OUT21/16593

**Borg Panels MOD 4 - Improved Layout (SSD-7016-Mod4)
Modification Report**

Detailed advice to DPE Planning & Assessment regarding Borg Panels MOD 4 – Improved Layout (SSD-7016-Mod4)

**Figure 8- proposed hardstand, effluent dam and mechanic's workshop**

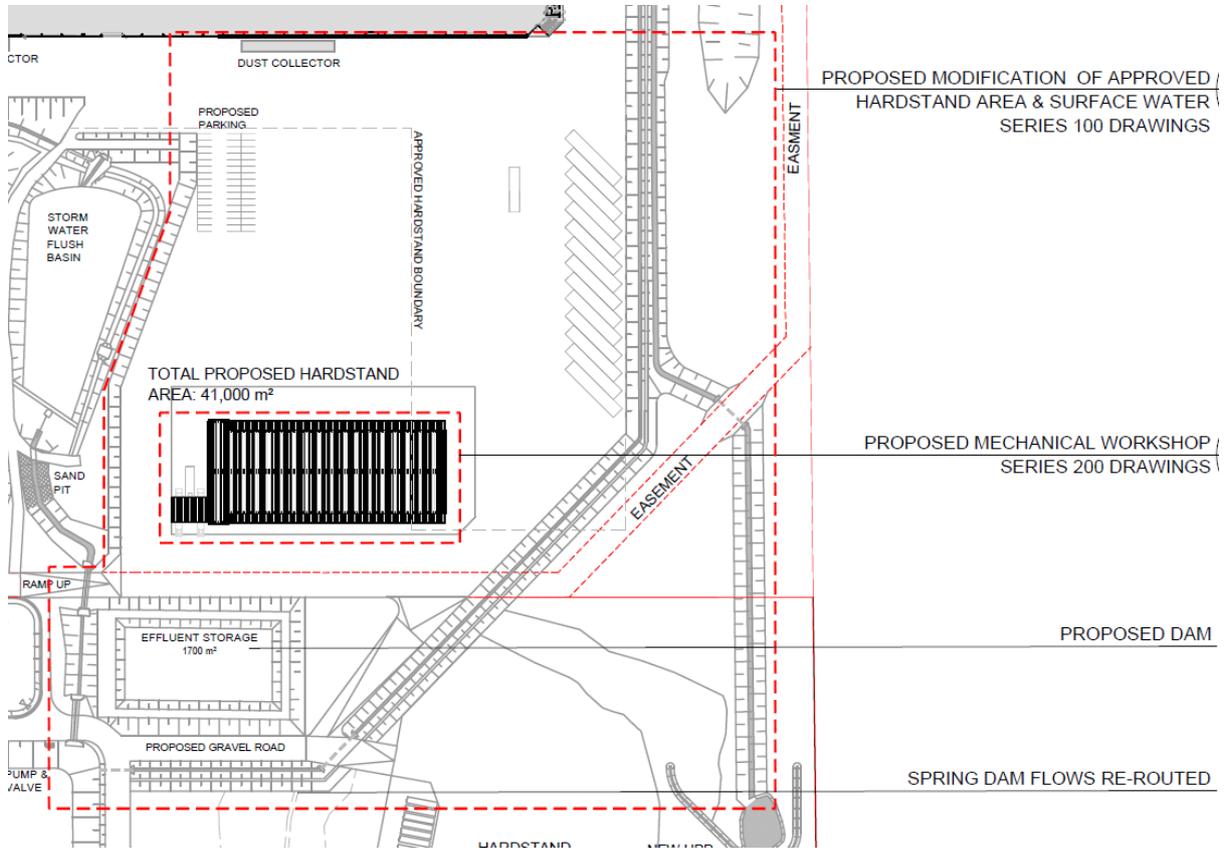
The specifics of how the proponent will retain access to groundwater from the spring fed dam have not been provided including how this relates to a water supply work and how groundwater flows are to be extracted or maintained through the site. Further detail is requested on the works proposed to extract and maintain pathways for groundwater at the spring fed dam and any new bores proposed at the site.

- Confirm whether the base of the proposed effluent basin will be above the high groundwater level. If not, demonstrate consideration of the activity as a potential aquifer interference activity.

The dimensions of the proposed effluent basin are indicated on drawings provided by the proponent. However, it is not clear whether the basin will intercept groundwater during construction or operation potentially constituting an aquifer interference activity and requiring additional assessment.
